Please ask for: Nicola Moore
Email: nicola.moore@arun.gov.uk
Telephone: Ext 37944
Our Ref: FG/31/22/CLP
Your Ref:
Date: 28th February 2022

Lawful Development Certificate for a Proposed Use or Development

Development: Lawful development certificate for a proposed single storey rear extension.
Location: 12 Highdown Close Ferring BN12 6PJ

B	1:500 Scale adjusted	Feb 2022
Revisions	A Dimensions added	Date Feb 2022
Client	Mrs. S. Clarke	
Project	12. Highdown Close Ferring BN12 6PJ	
Title	Proposed site and location plan	
Scale 1:500	Date Sept 2021	Drawn KEL
Paper Size A3	Doc No 005

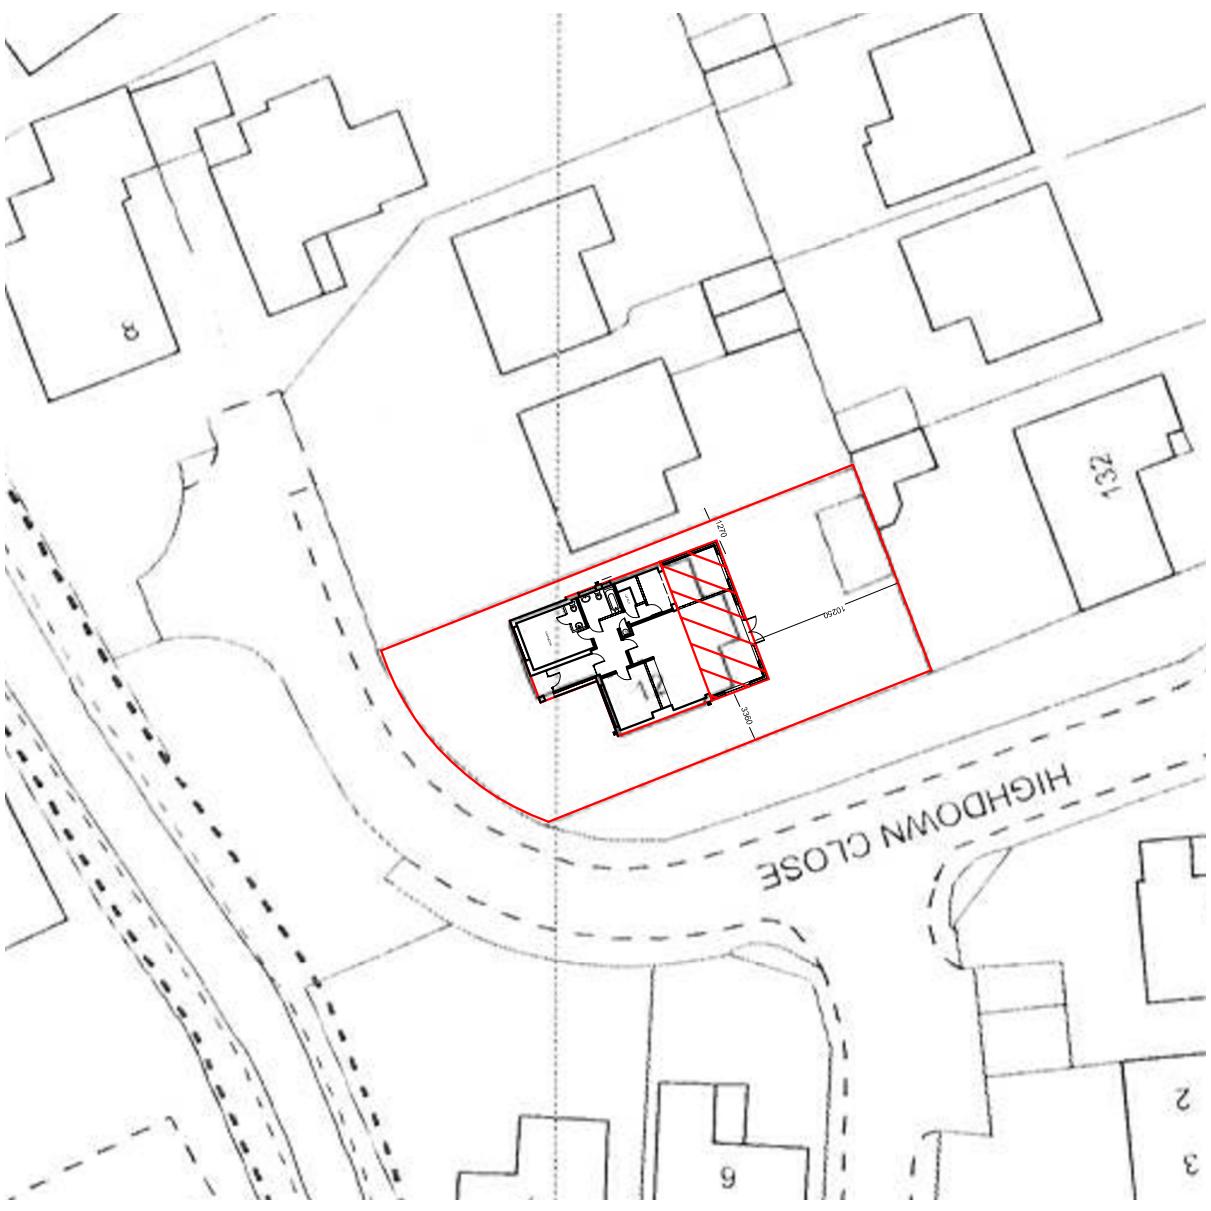
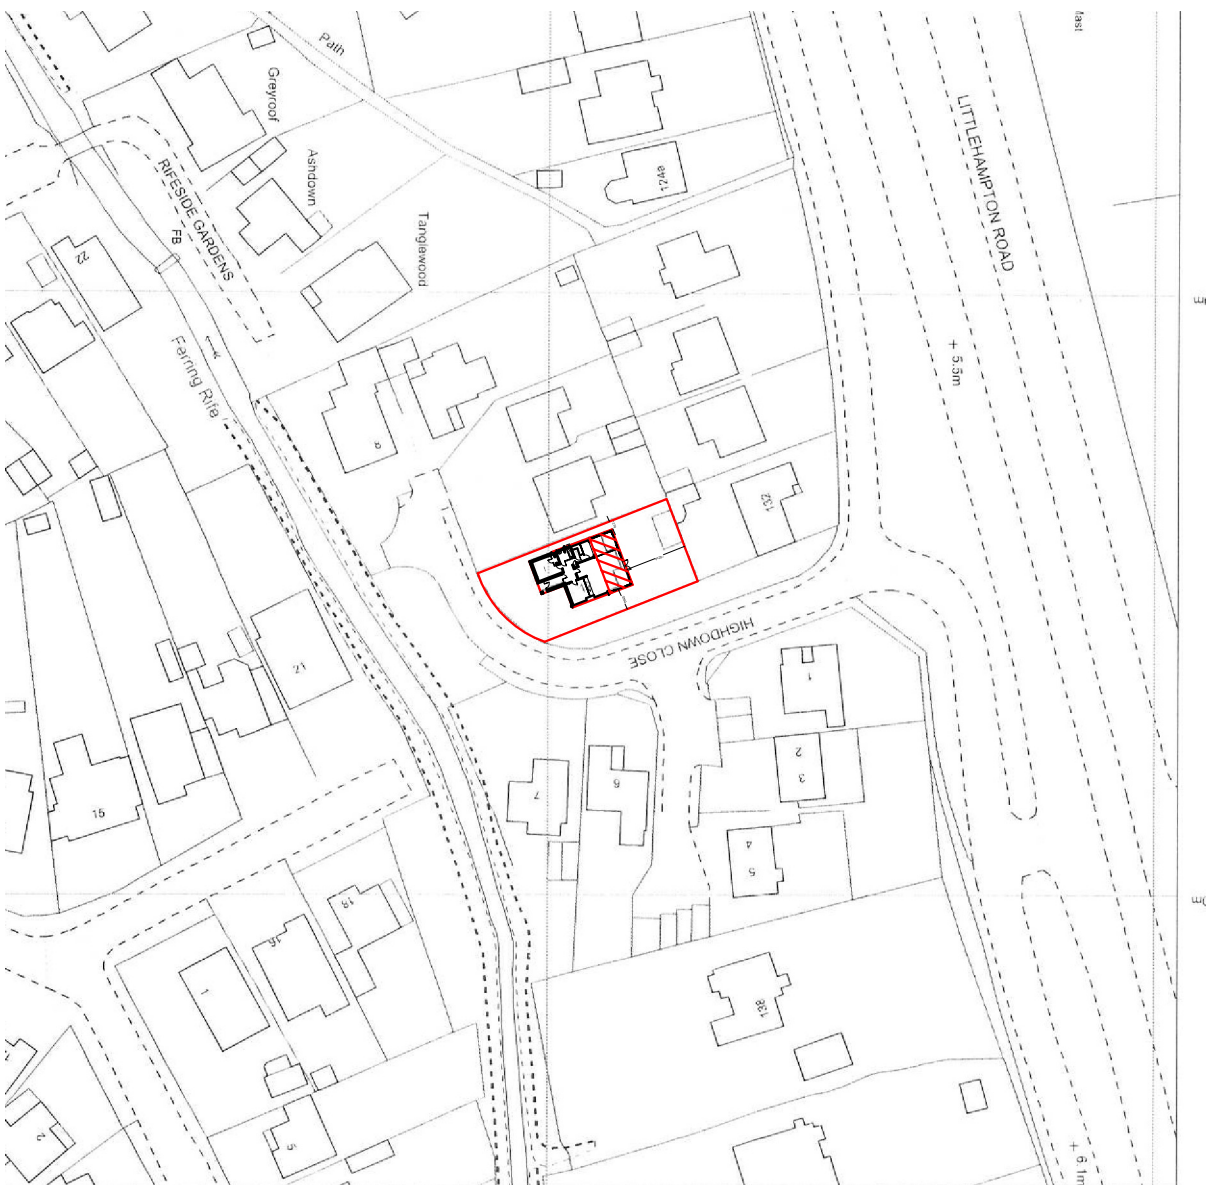
The distance to the rear boundary on the Block plan is 10.250m but when measured is 14.20m at 1:500. Please check the distance to boundary measurements, amend accordingly and re submit.
